**PROJECT TITLE**  
Congress Street  
Building  
22 Bramhall Street  
Portland, ME 04102

**RESUBMIT TO CITY**  
DECEMBER 10, 2018

**TITLE**  
LANDSCAPE PLAN,  
UPPER CONGRESS,  
CONGRESS STREET  
EXPANSION

**SHEET NUMBER**  
C50-01

CONGRESS STREET

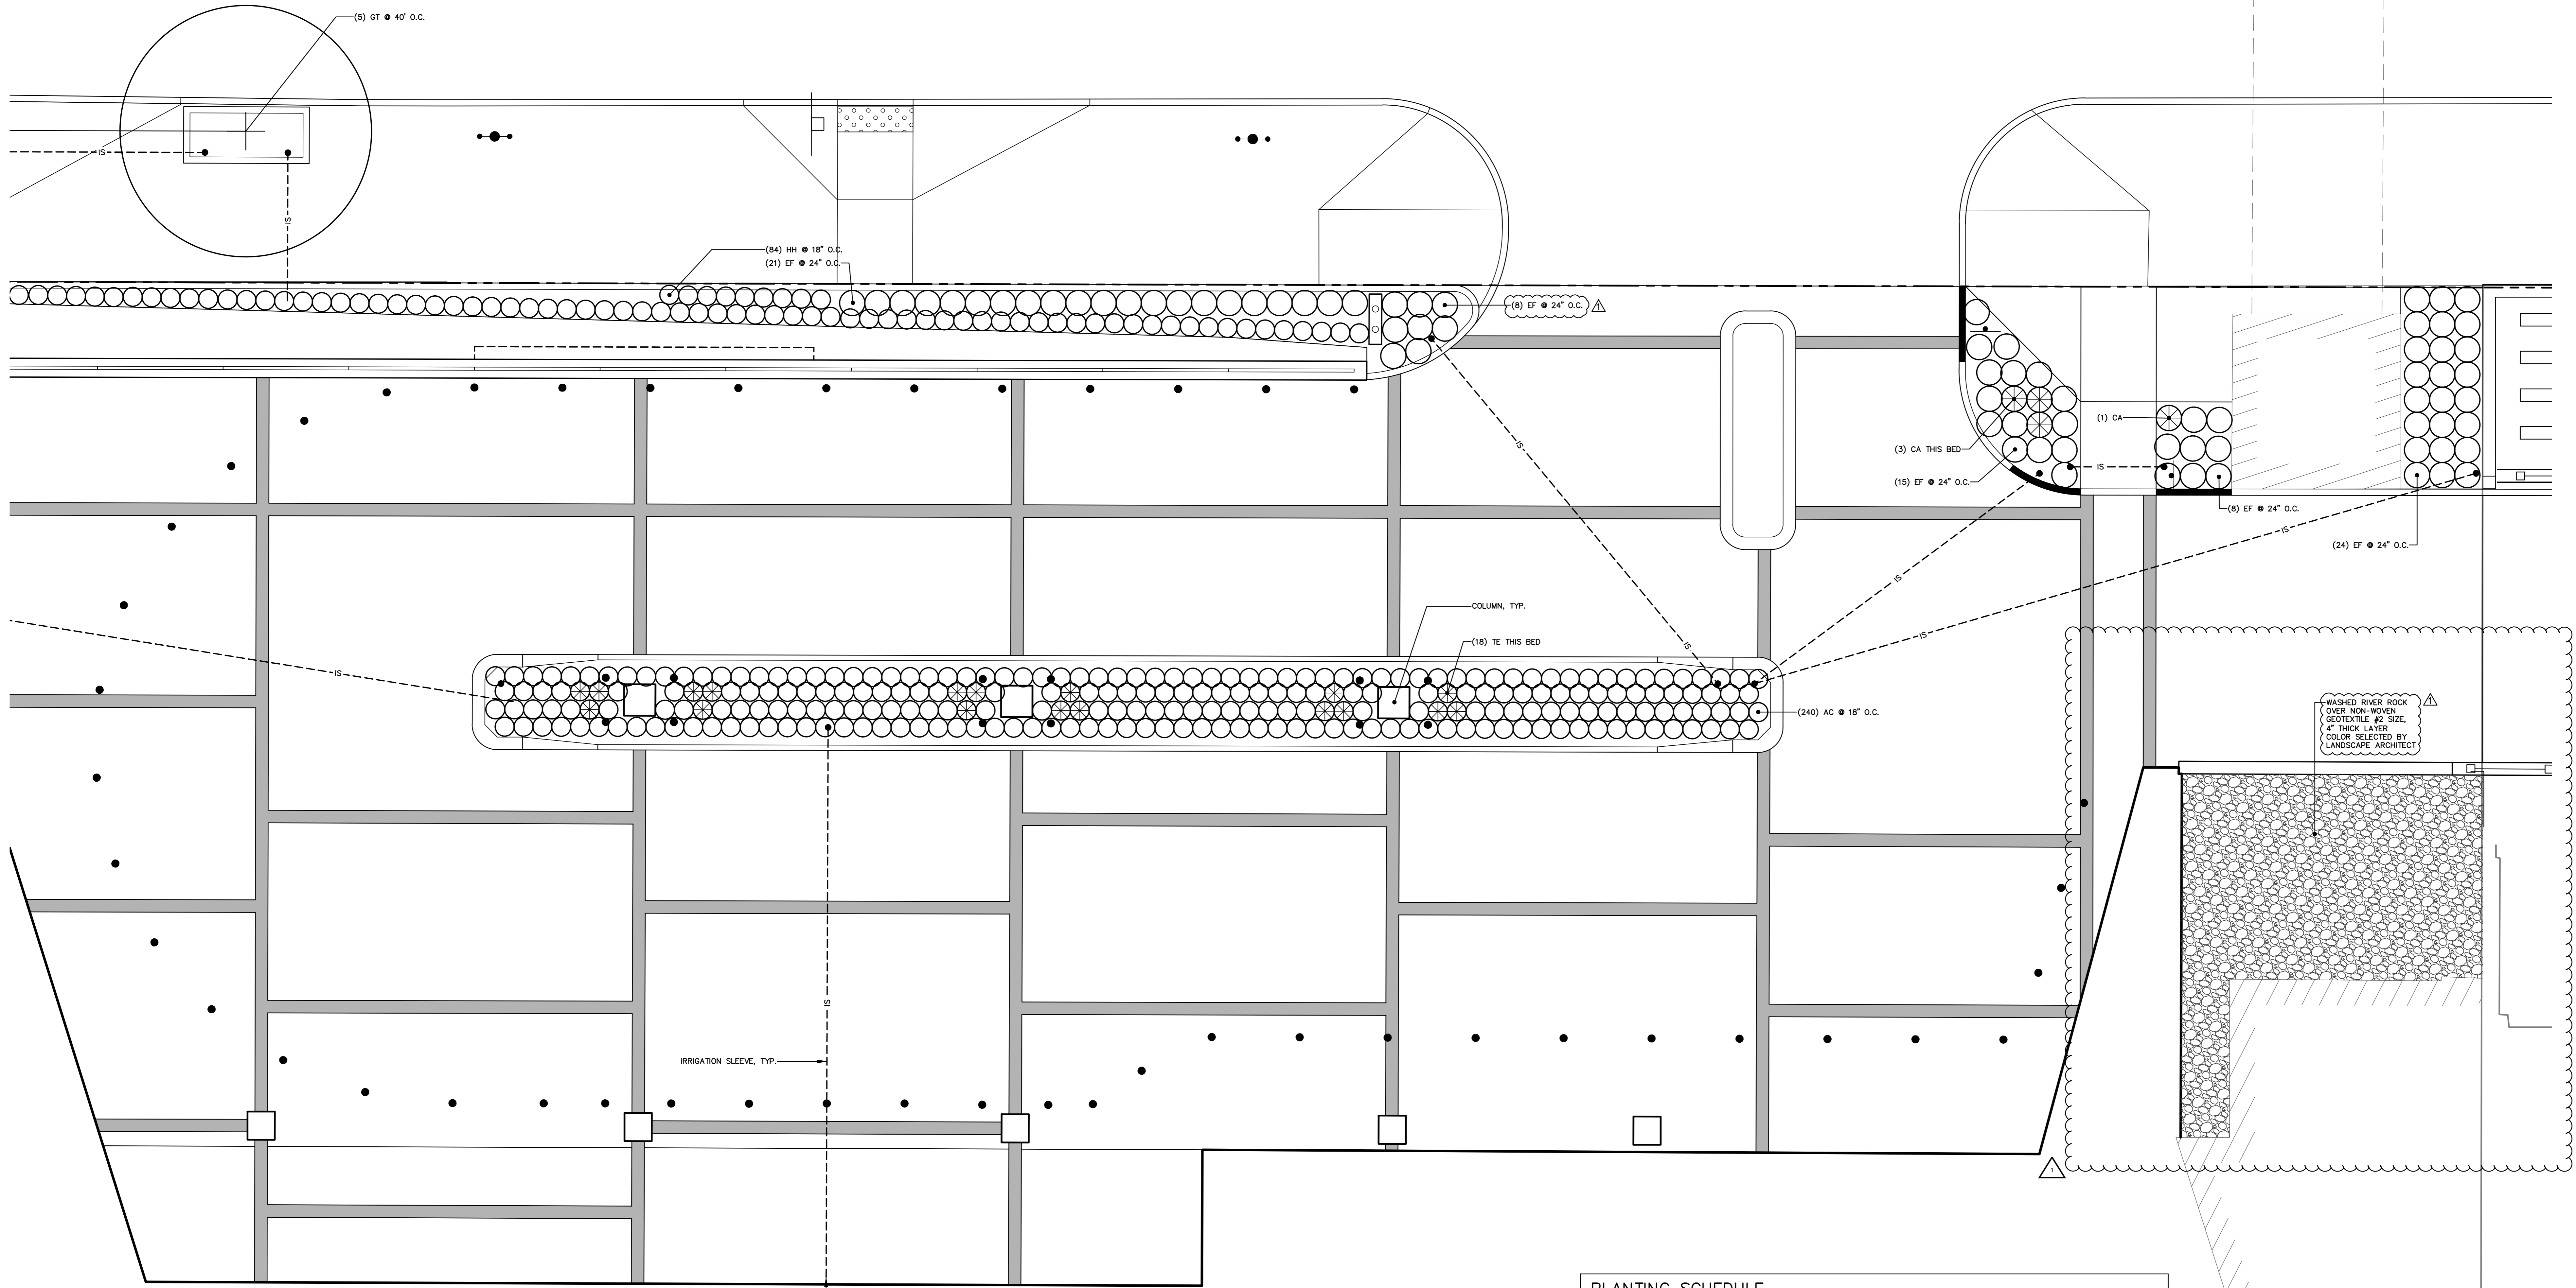
Support this change  
vertical edge req. here

this should remain planted  
w/ vertical edge transition  
at sidewalk

*Any time  
planter next to  
sidewalk (this  
needs to be  
vertical edge  
curb or planter)*

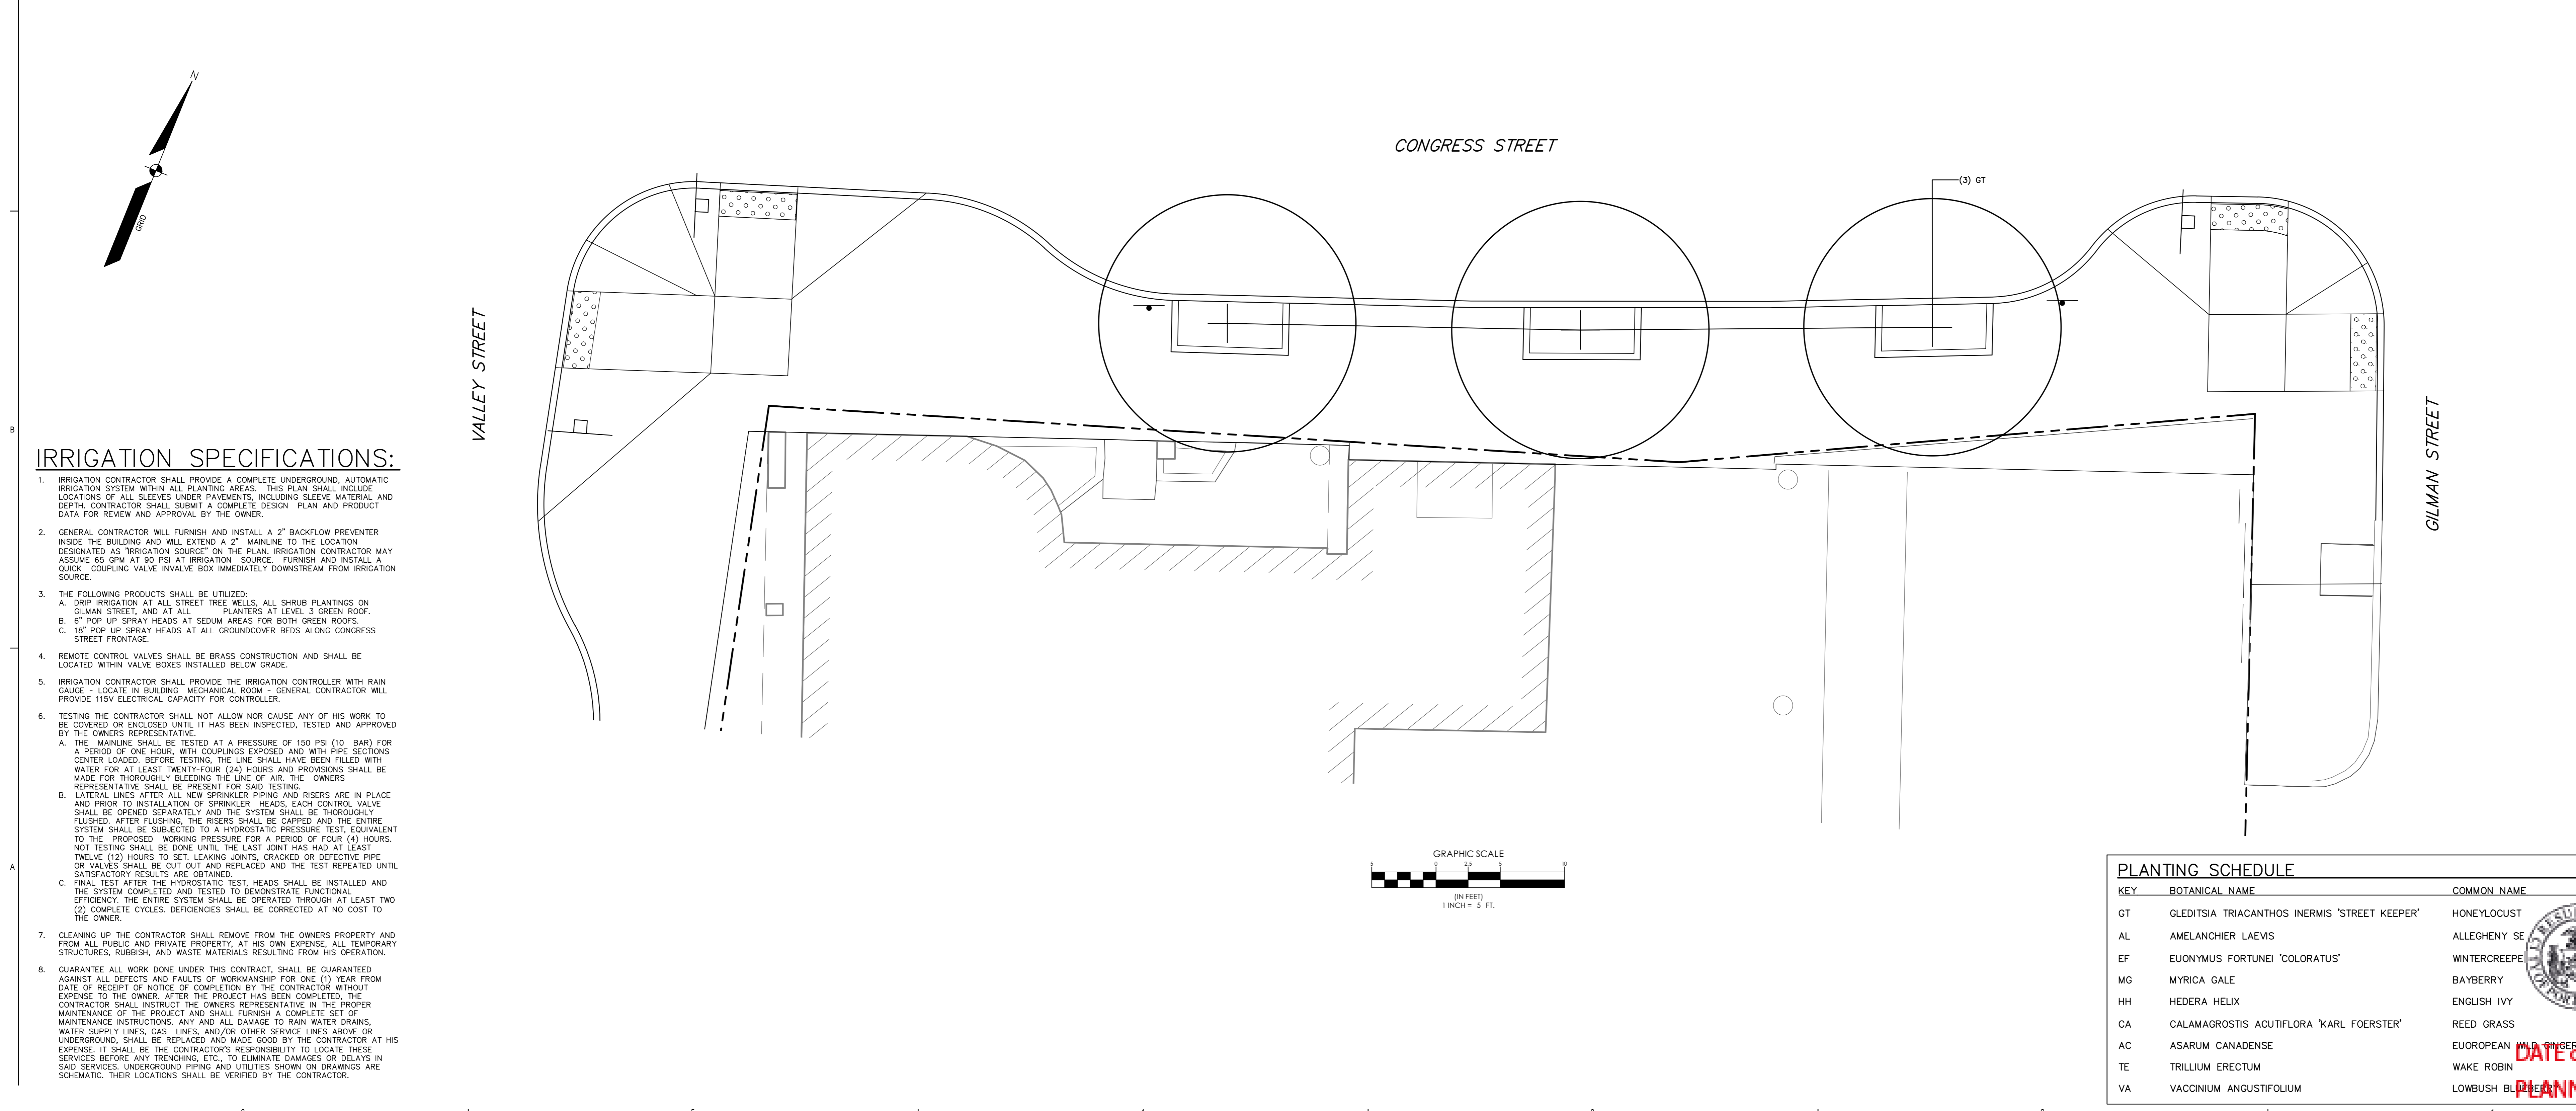
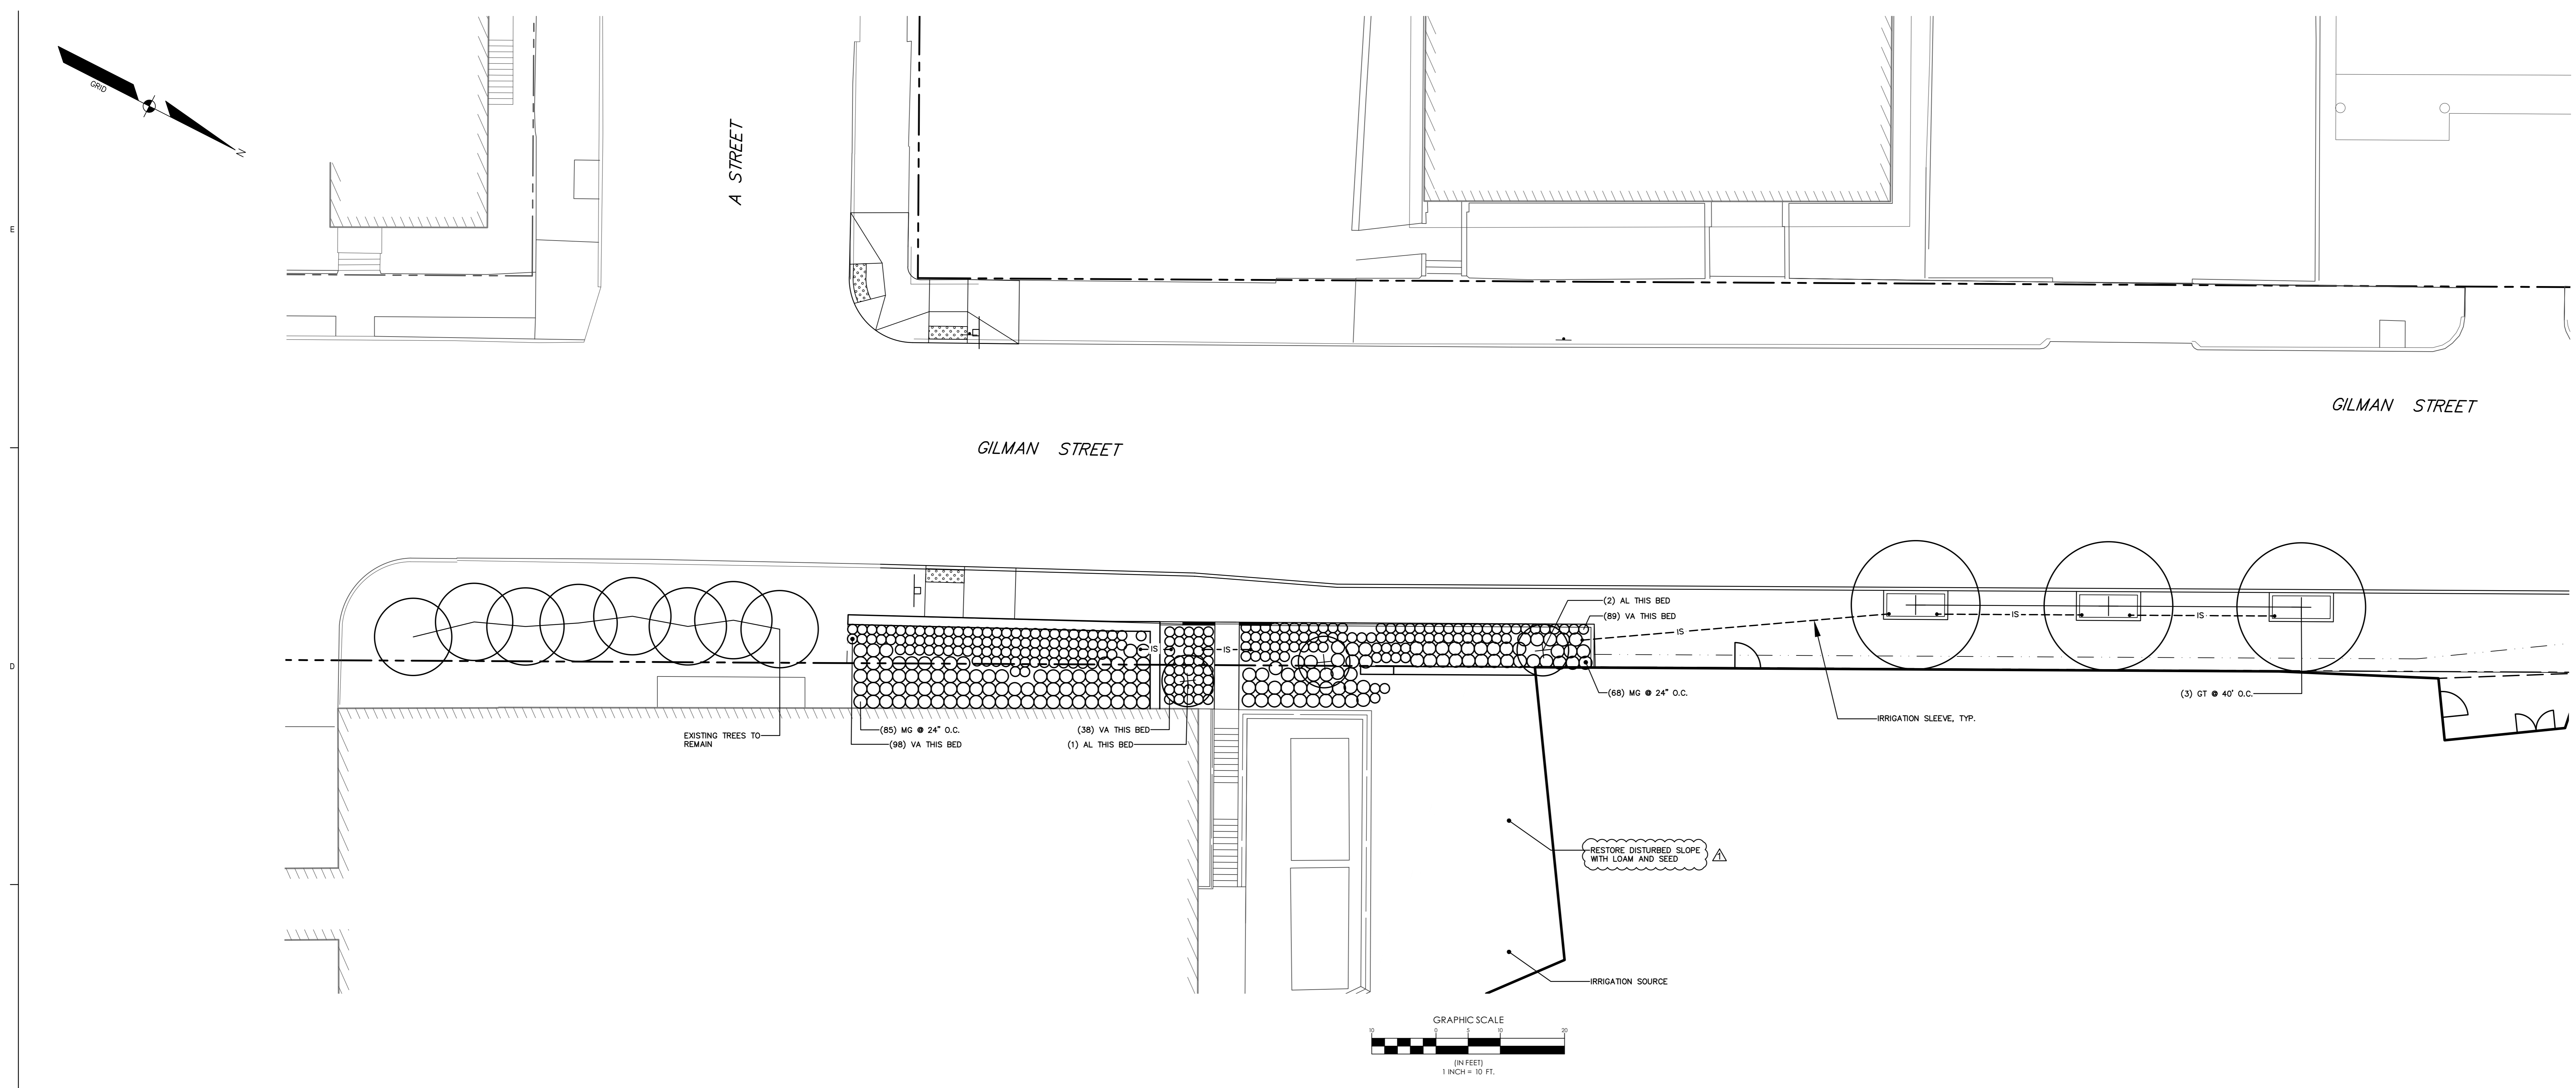
Any time there is landscape next to sidewalk = vertical edge (curb or planter wall)

radius corners highly recommended
